ENG-CDR21014-R4-DR.pdf Markup Summary

PROPOSED CONDITION WORK MAP

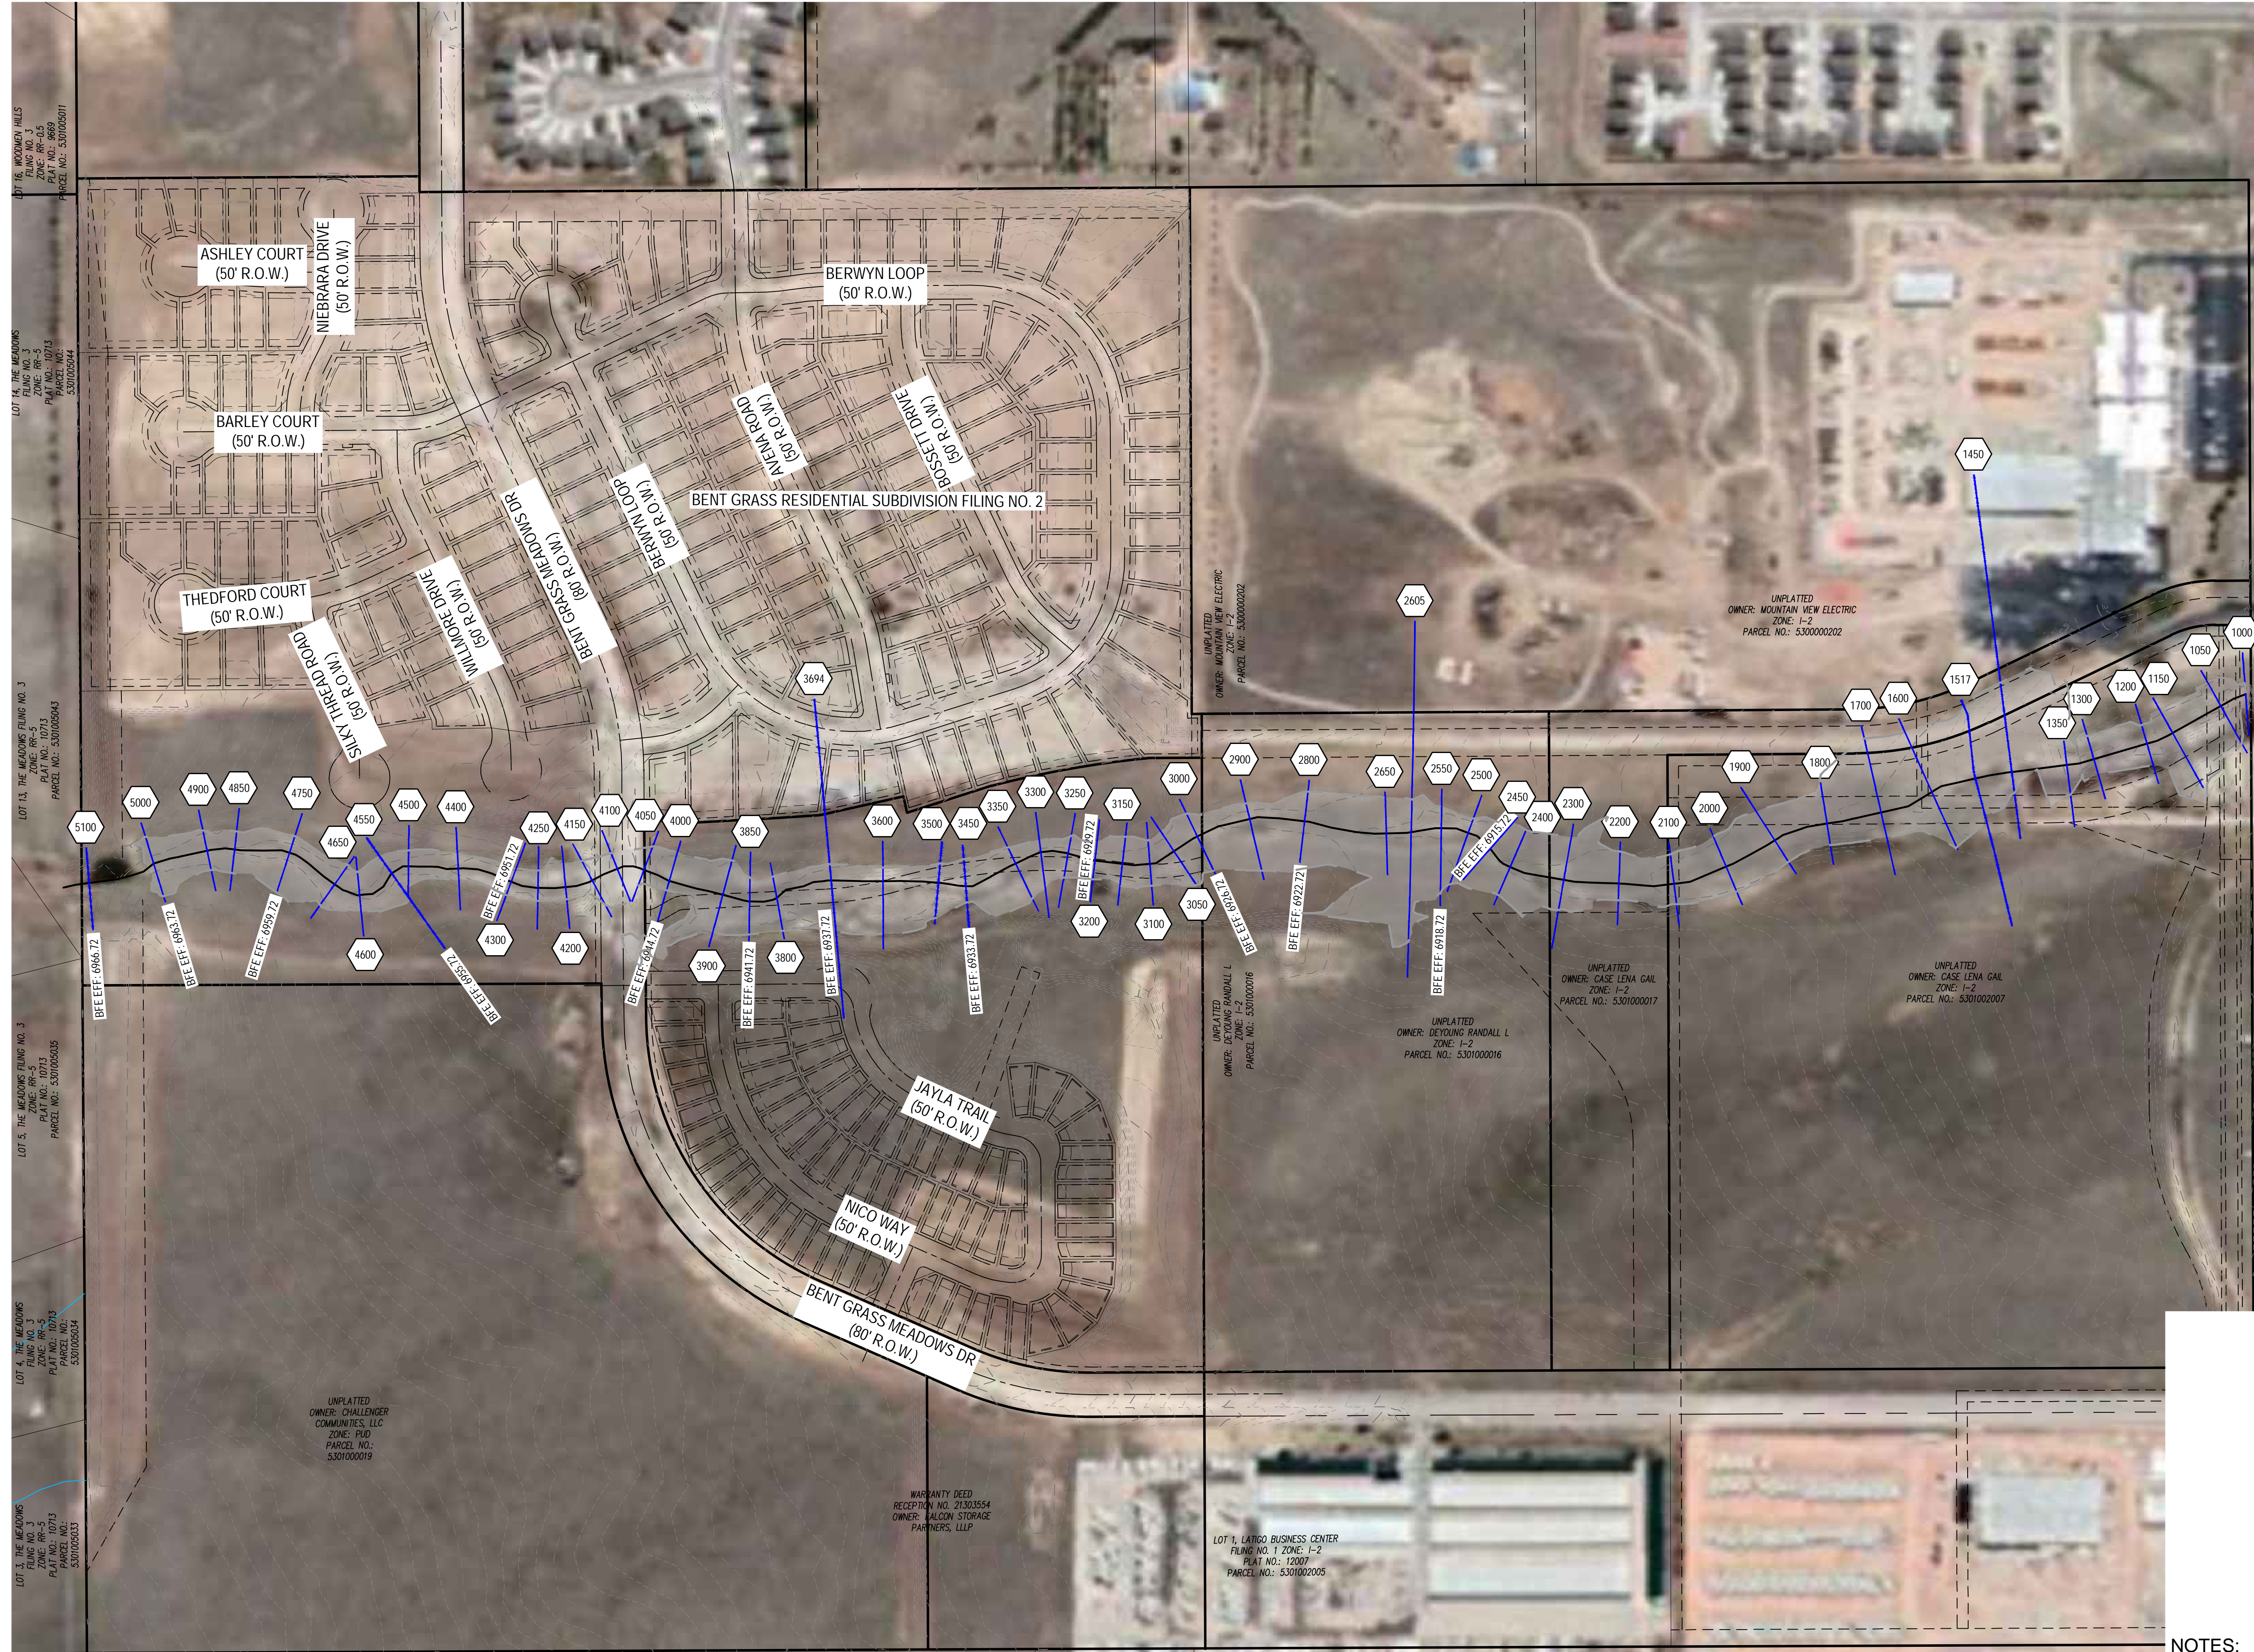
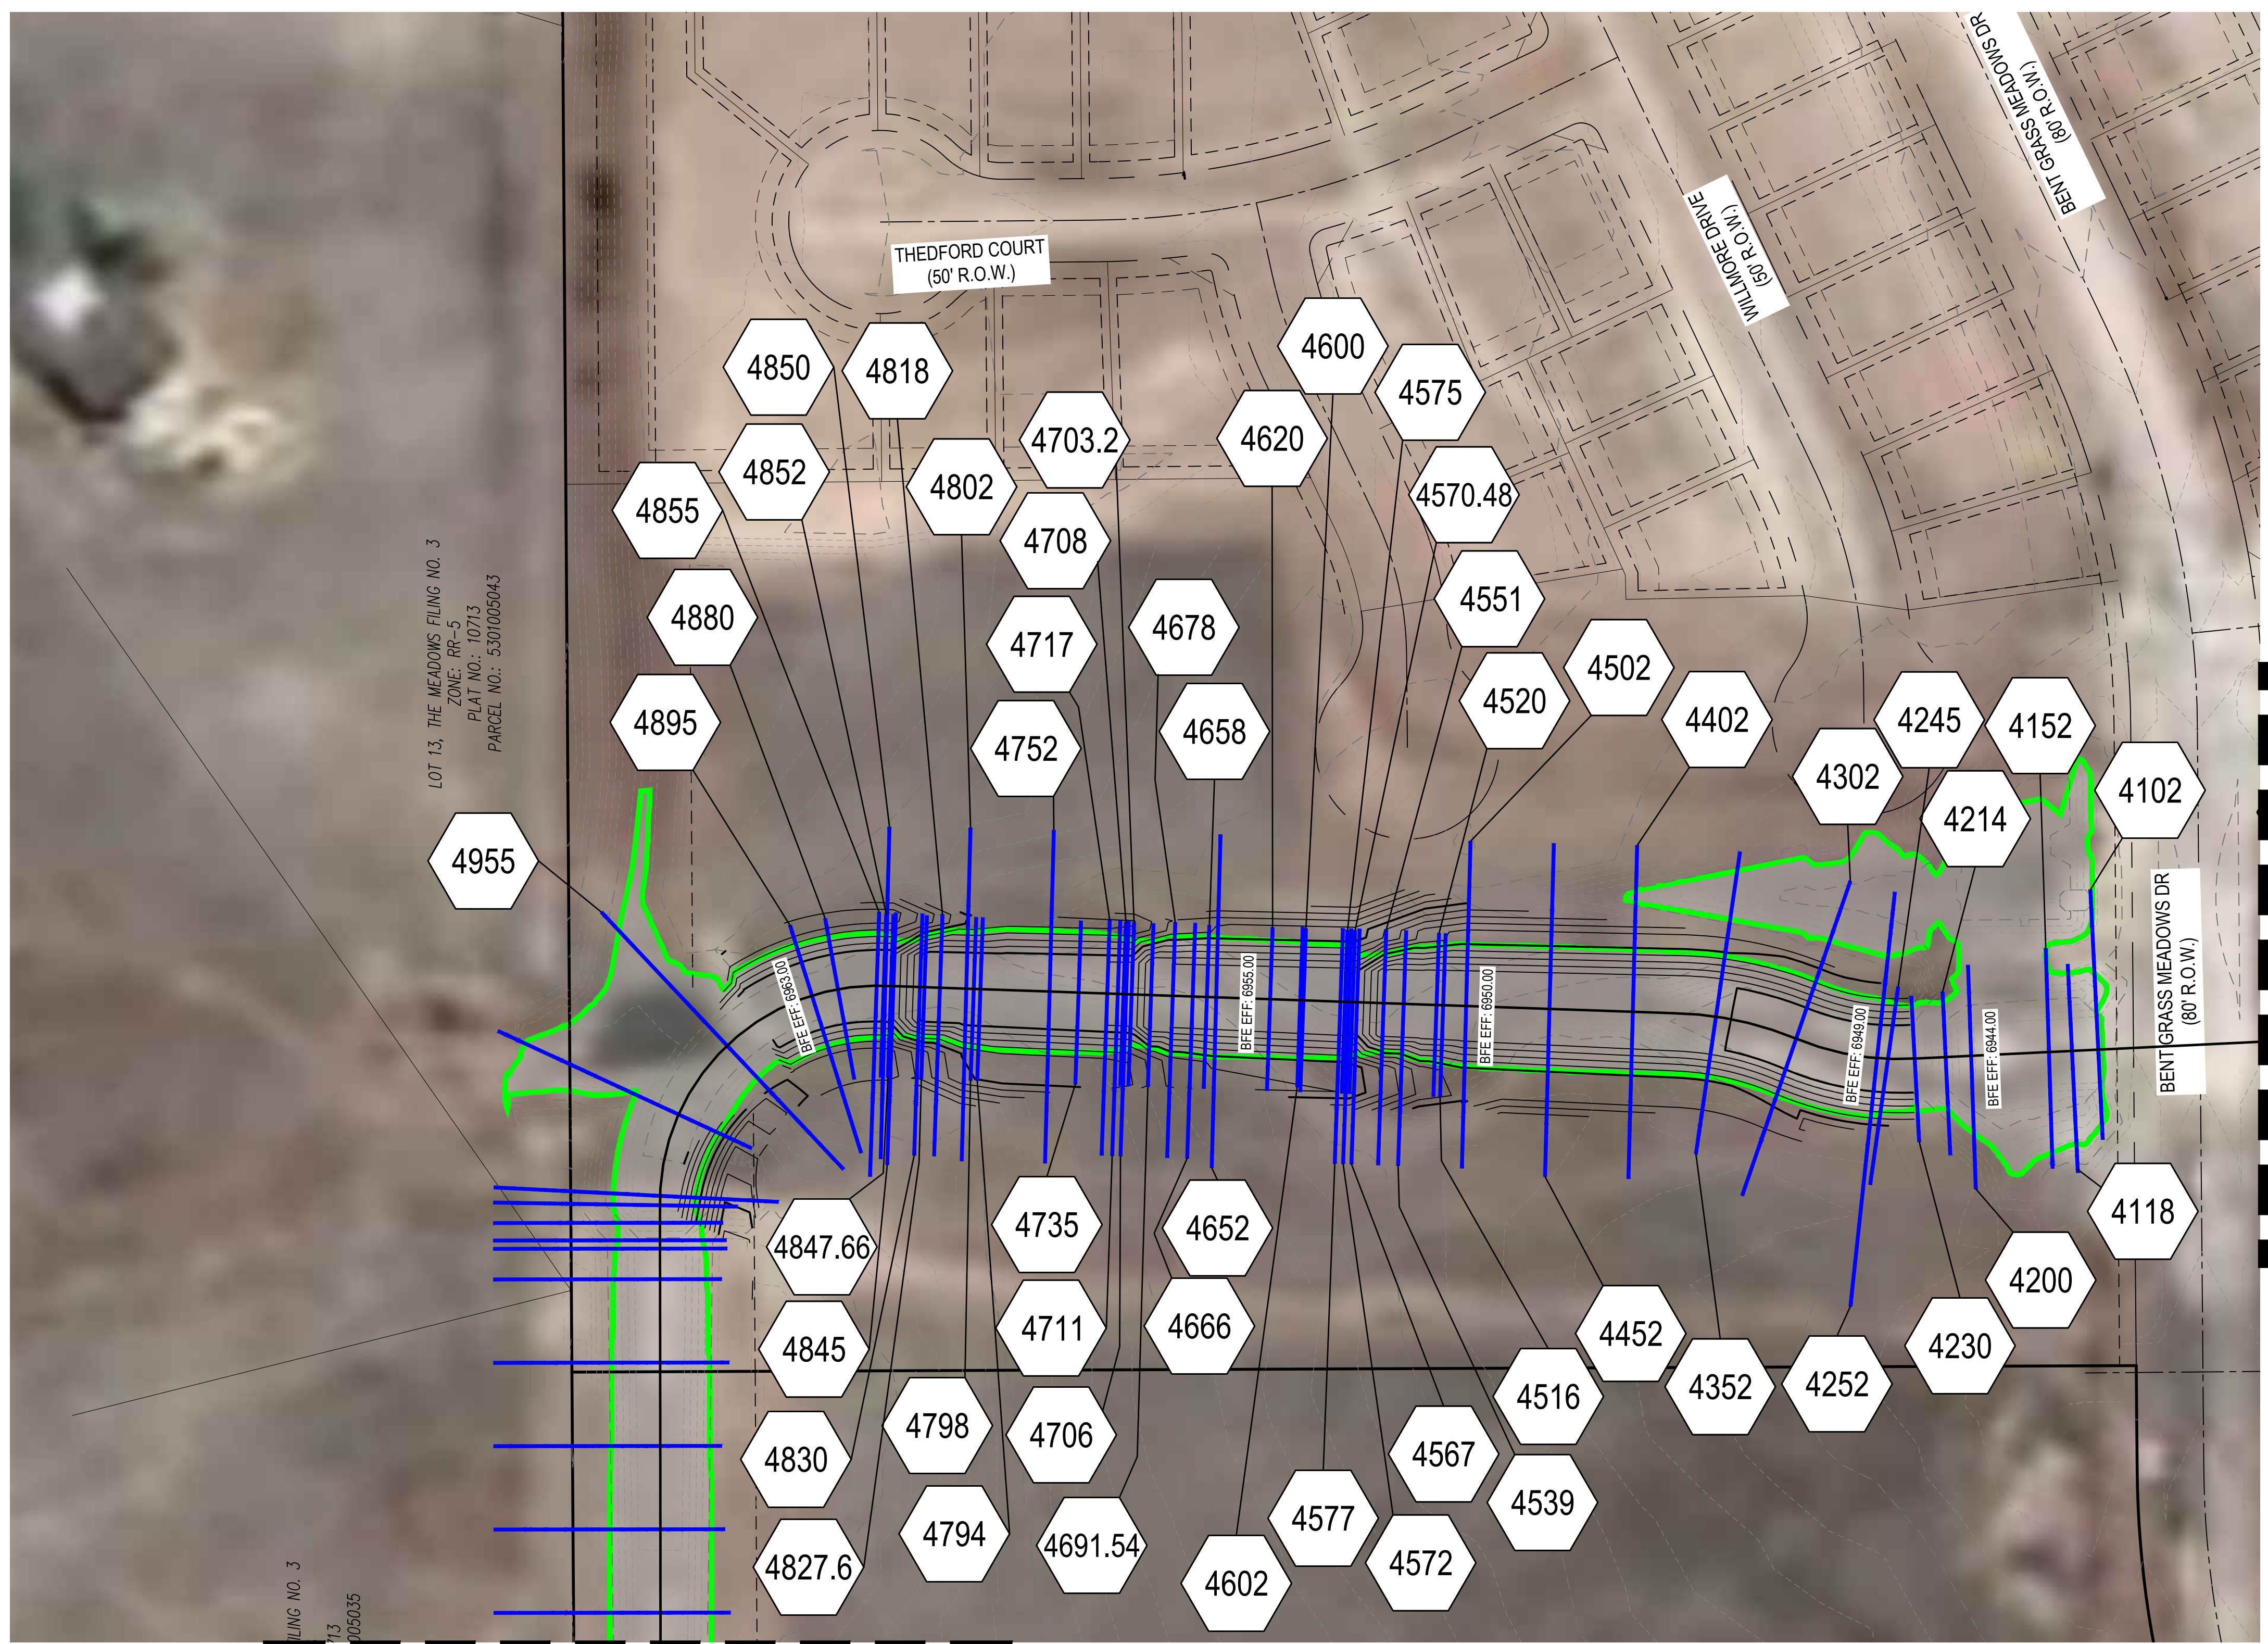
Provide shear stress calculations and specifically address in the low flow channel and bends.

provide shear stresses for this channel
